Consultation response from Tree Officer

Planning Application Ref: EP/42/17/PL

Location: Public Conveniences, Sea Road, East Preston

Description of works: Alterations to existing public conveniences including provision for disabled facilities and ramped access to toilet.

Client: East Preston Parish Council	
Project Address: Toilets Sea Road East Preston	
Drawing Title: Existing and Proposed Plans and Elevations	
Drawing Number: 1059.01.d	
Scale:	As stated printed @ A1
Date:	14/10/2016

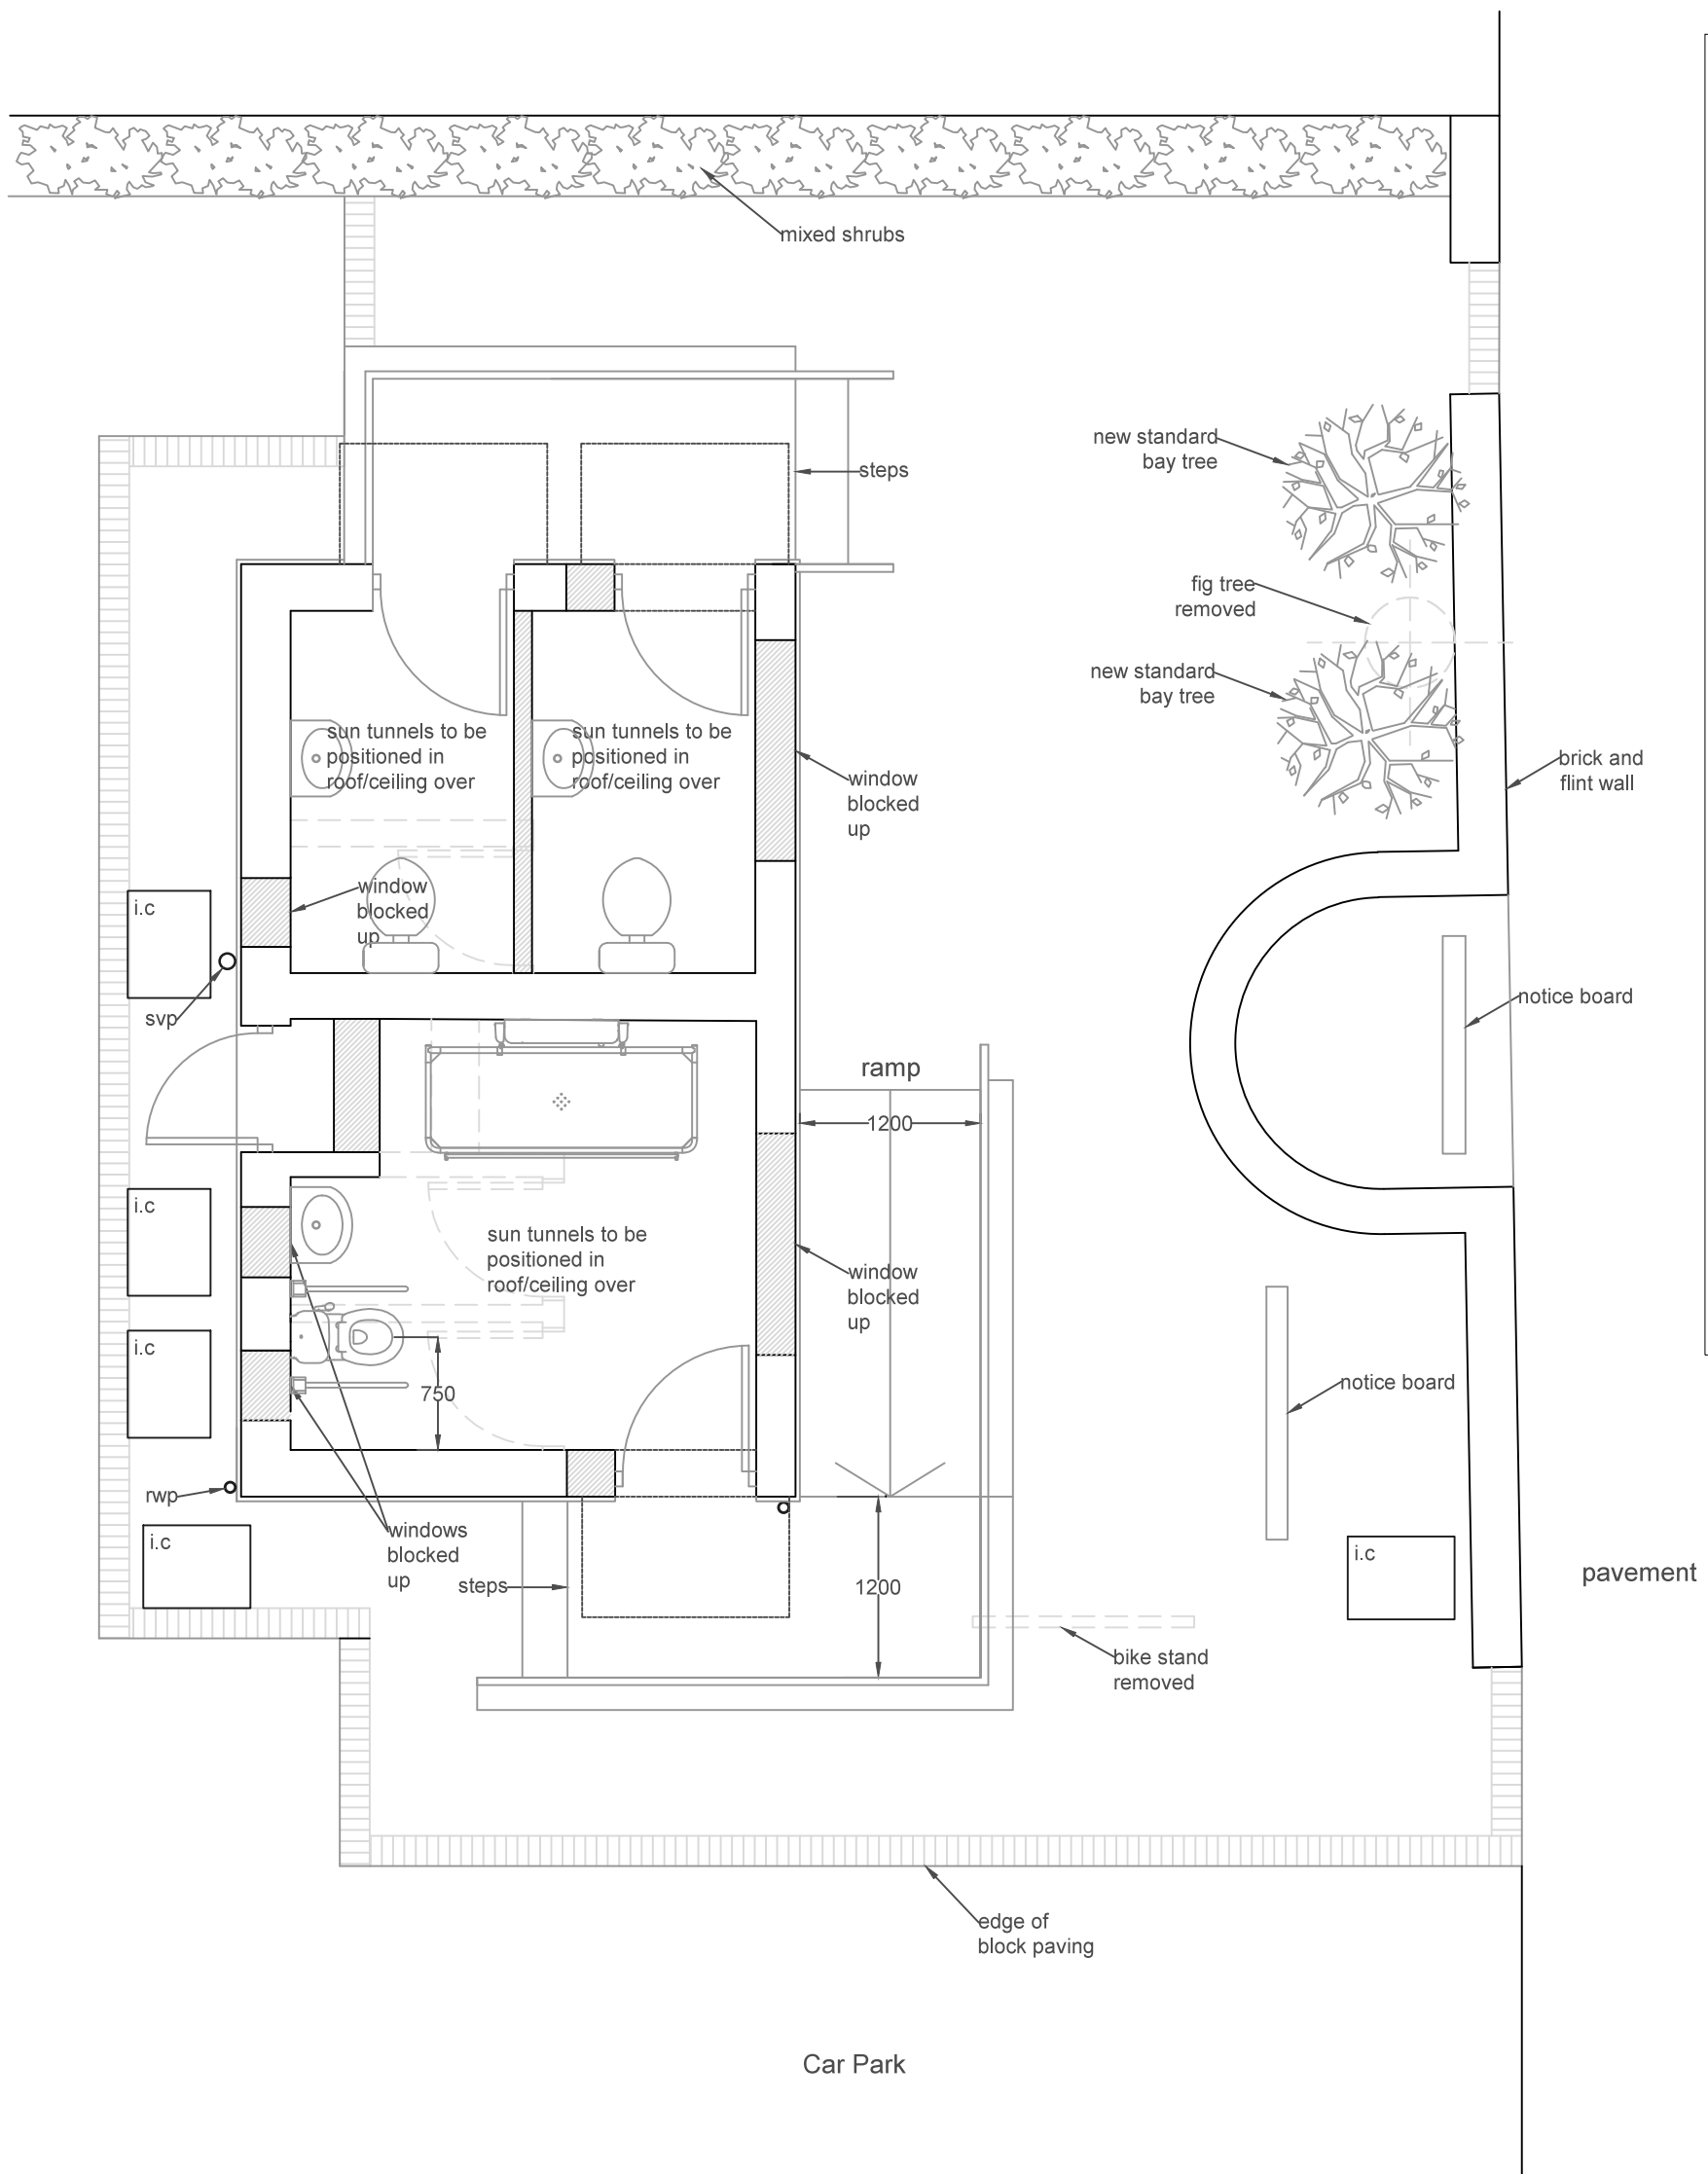
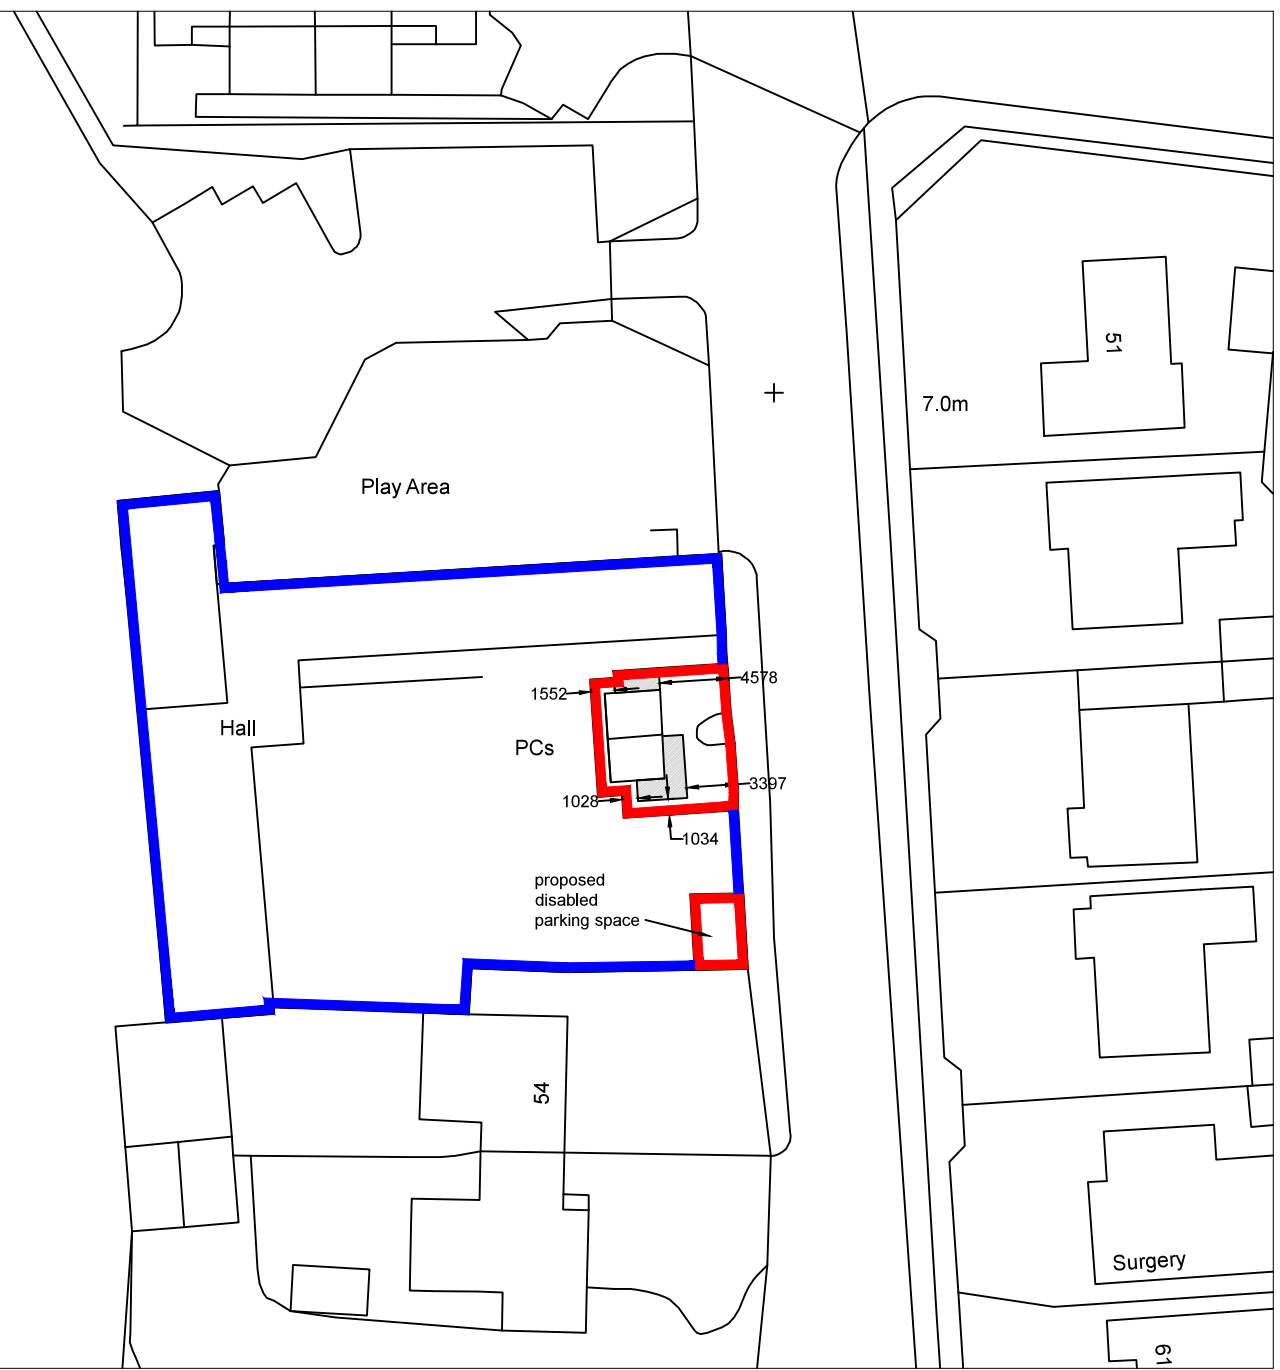
Please find attached comments from our tree officer. I have discussed them with Juan. As planners we agree that the fig can be removed. Without prejudice, I would appreciate receipt of a revised proposed layout plan deleting reference to provision of 2 bay trees and indicating a semi-mature replacement tree of a species to be agreed. This will then be controlled by condition.

- I would recommend that this tree is retained and managed with pruning works.
- However, if planners see fit to approve the removal as part of the redevelopment works then I would like to see one quality semi-mature replacement tree planted in its place - of a species to be agreed.
- The applicants show two new Bay Laurel trees being planted which in my opinion would not be suitable and would not adequately mitigate the loss of amenity value provided by the Fig.
